From: Caroline Ford
Sent: 26 January 2022 16:39
To: DC Support
Subject: FW: 21/03177/F - Axis J9 Phase 3, Howes Lane, Bicester
Attachments: RFM-XX-00-RP-L-0003-PL01 Phase 2 Landscape management and maintenance plan (1).pdf

From: Tim Screen <Tim.Screen@Cherwell-DC.gov.uk>
Sent: 17 January 2022 14:11
To: Caroline Ford <Caroline.Ford@Cherwell-DC.gov.uk>
Subject: 21/03177/F - Axis J9 Phase 3, Howes Lane, Bicester

Review of LVIA and Planting Strategy Drawing

Fig. 18 Landscaping

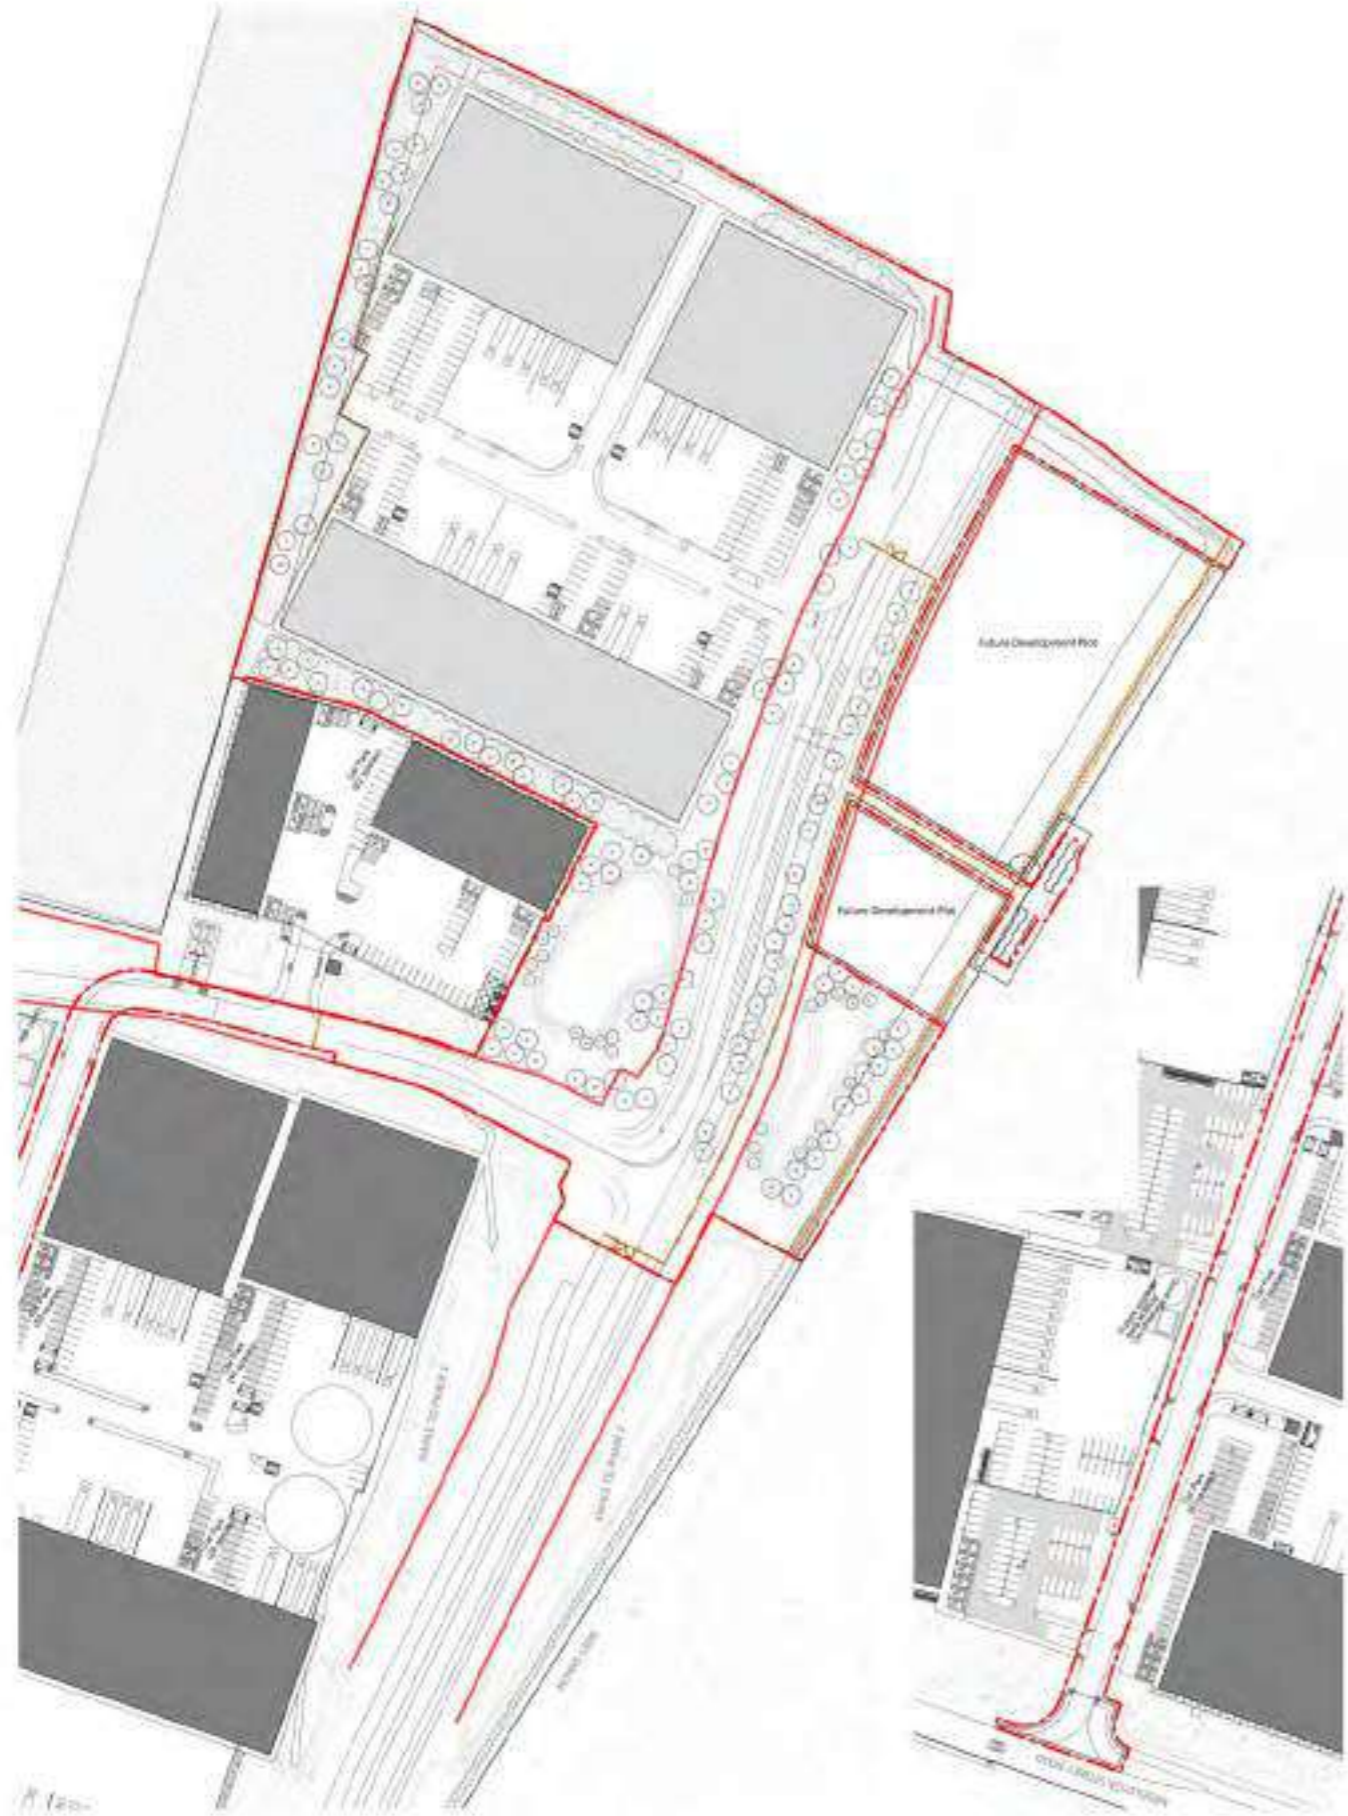
I agree with much of the visual narrative and results and concluded that the screening and visual mitigation of the buildings indicated on the Planting Strategy Drawing:

- a) for the benefit of existing residents east of Howes Lane afforded by the proposed 'treescape' on the Planting Strategy Drawing is acceptable;
- b) also screening and visual mitigation of the buildings for the benefit of future residential receptors west of the development is afforded by the existing off site woodland plantation;
- c) the roadside receptor approach on the new road will benefit from the 'treescape' proposed.

However, the northern site boundary's existing hedgerow does not successfully provide sufficient screening or buffering of the 16 m high unit to the disbenefit of school/visual receptors. If additional space was provided between the boundary and the building to allow for large native trees in irregular natural groupings; interplanted throughout the hedgerow (the hedgerow will act as an understory), this would benefit the scheme – details to be submitted for our consideration.

Salix fragilis (Crack Willow) should be removed from the scheme. As its name suggests, as it matures its limbs are going to split and fall.

Sorbus leyana is a rare tree going in the Brecon Beacons and not widely available from nurseries. It is a tree that may not be appropriate for the soil condition. Plant *Sorbus aria* instead.

The landscape maintenance access entrances and site access control measures are to be indicated (to prevent unauthorised access).

It is important to indicate the positions of the species on detailed soft landscape proposals. A planting schedules (numbers and supplied sizes) and aftercare specification to be included, along with tree pit planting details.
